From: Natalie McKellar [REDACTED]
Sent: 31 May 2019 11:36
To: Simon Davis <Simon.Davis@arun.gov.uk>
Cc: Kerry Simmons [REDACTED]
Subject: RE: AW/28/19/PL

Subject: FW: AW/28/19/PL

Please see Tree comments received last week. Please can you provide the requested additional details regarding no dig, levels and drainage /service runs.

Tree Constraints Plan 276 Aldwick Road, Bognor Regis

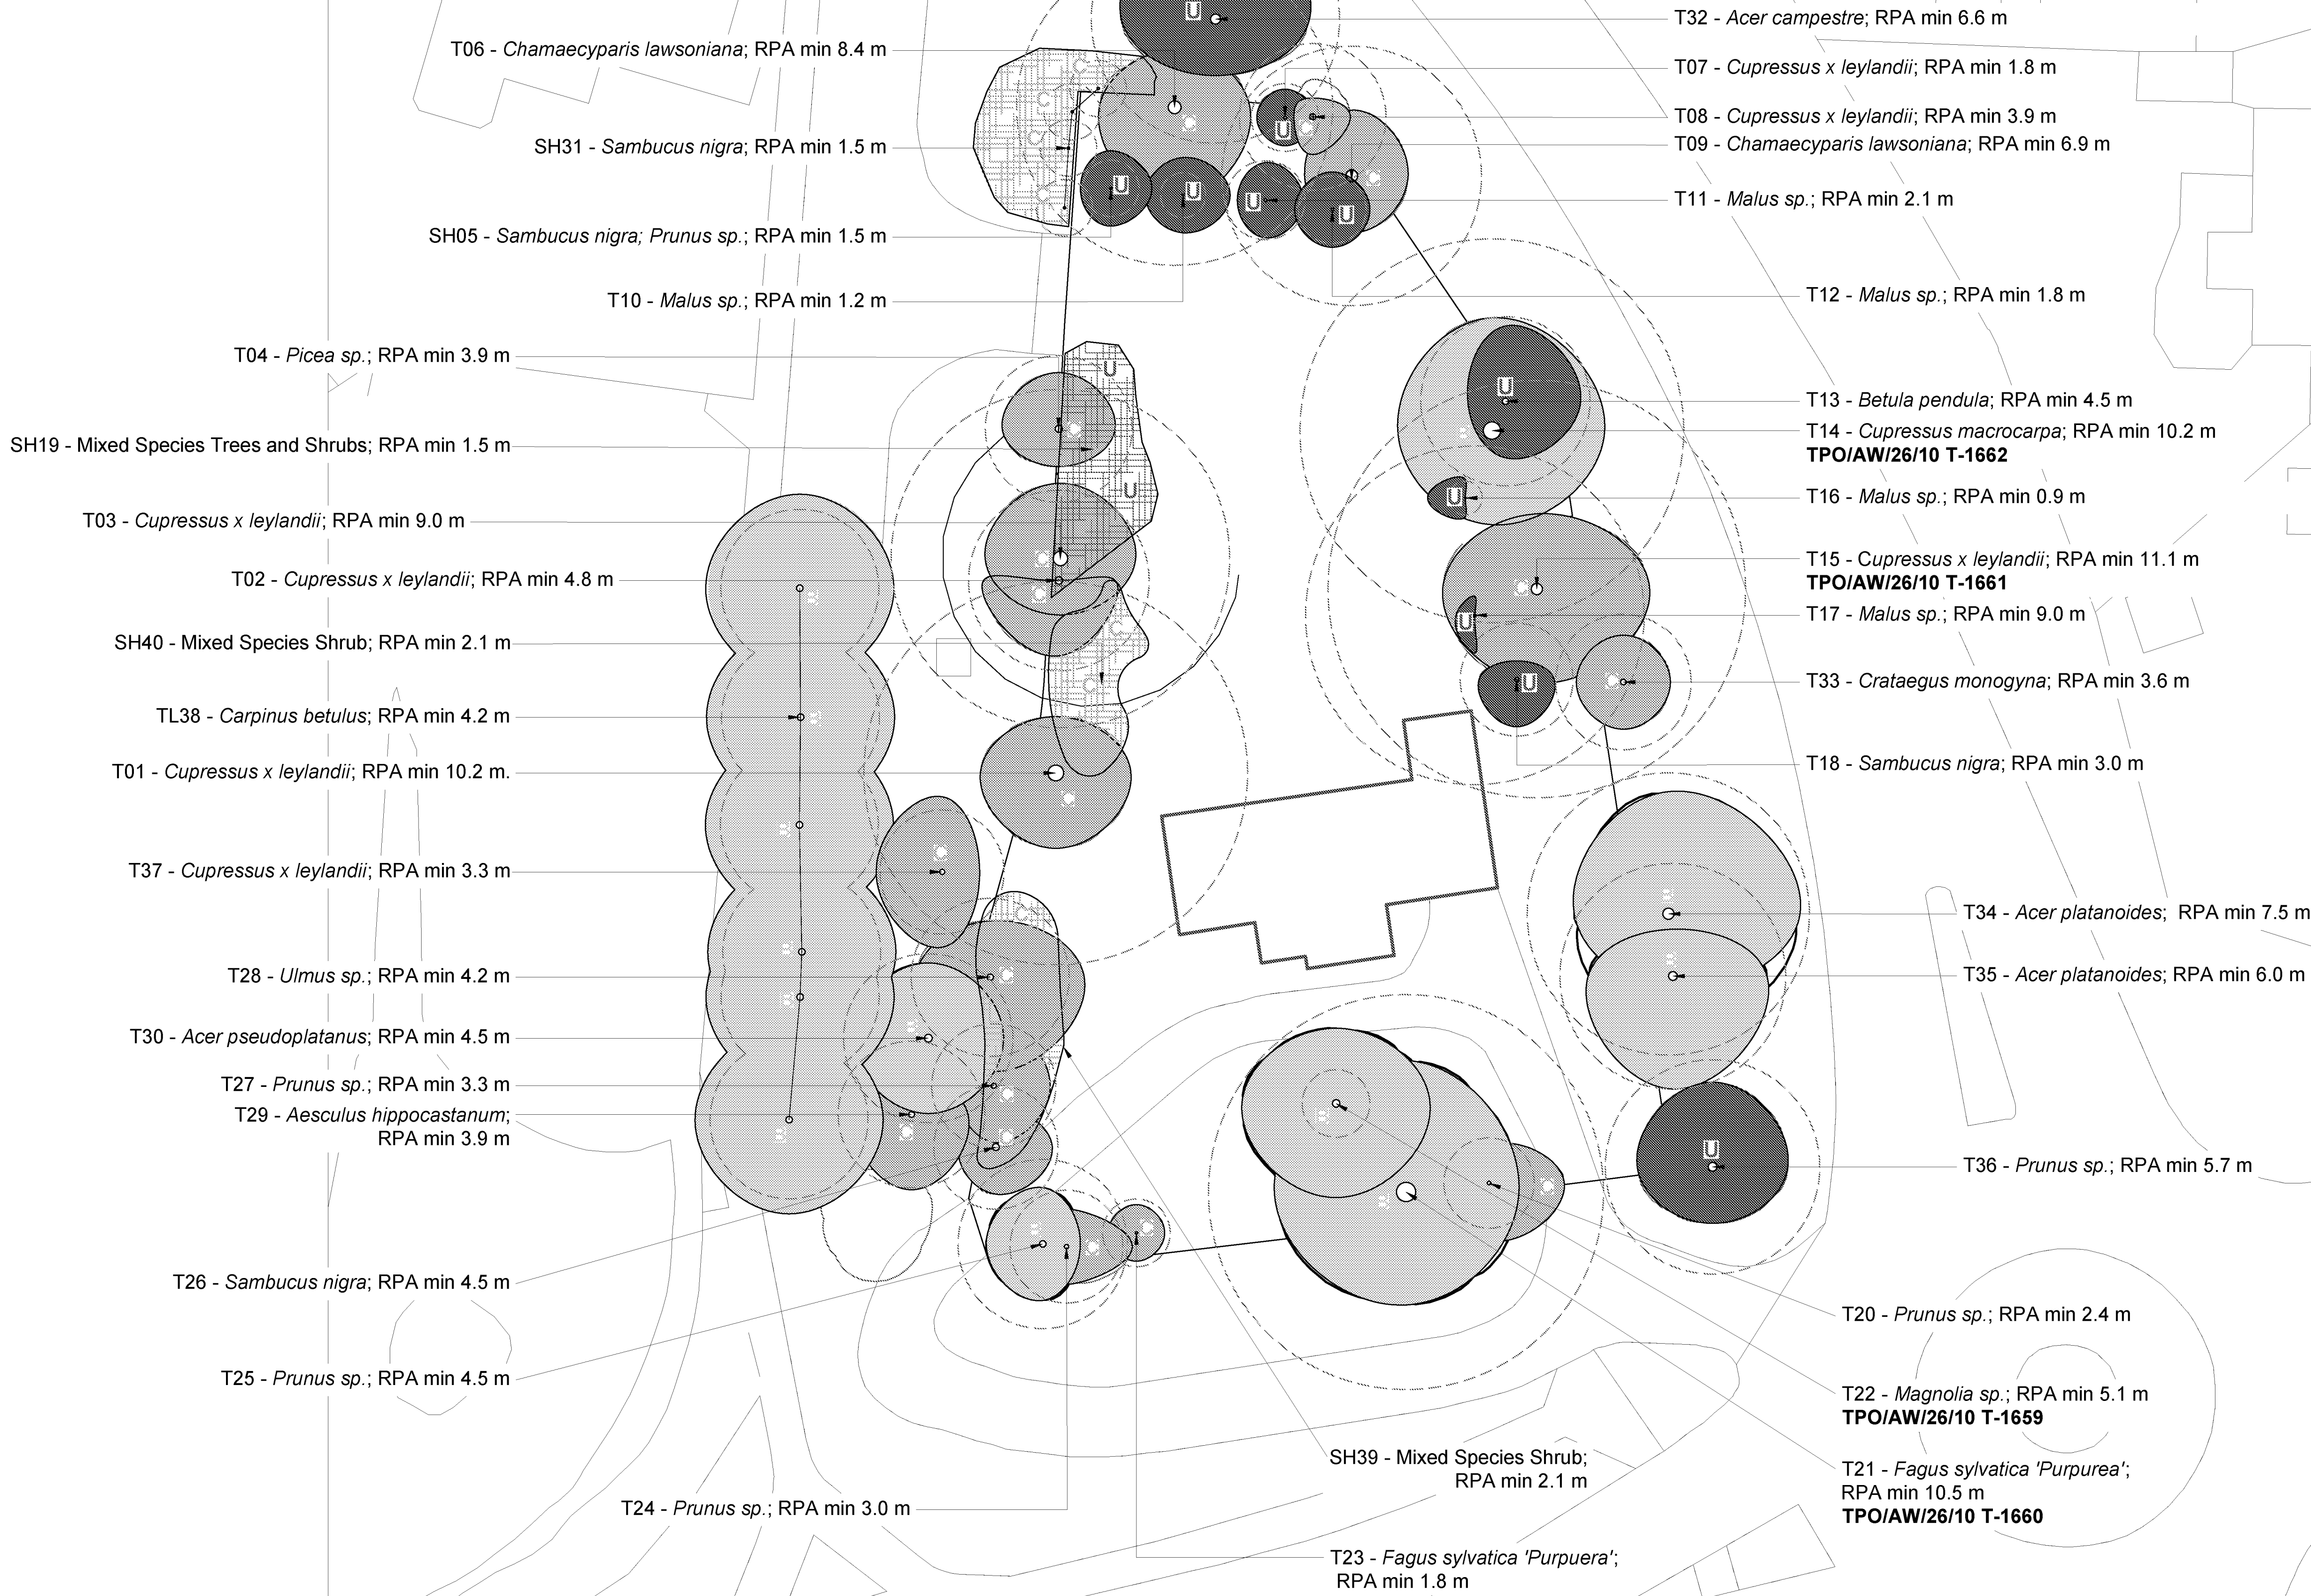
You may also want to consider amending the proposal to reduce the impact on trees generally. You could consider for example making the house 2 bedrooms and removing the southern 'wing', also potentially reducing the area of hardstanding?

I can confirm that Lizard Landscape will be preparing some further information including sections through the no-dig zone based upon existing site levels and proposed finished floor level. Whilst a number of category C trees are proposed to be removed as part of the proposals it is considered that these can be replaced with better quality trees, with better species selection and this is something that can be controlled by condition. Our client is looking at the areas of hard standing proposed and I expect a revised drawing reducing the areas of hard standing to reduce impact on root protection areas shortly.
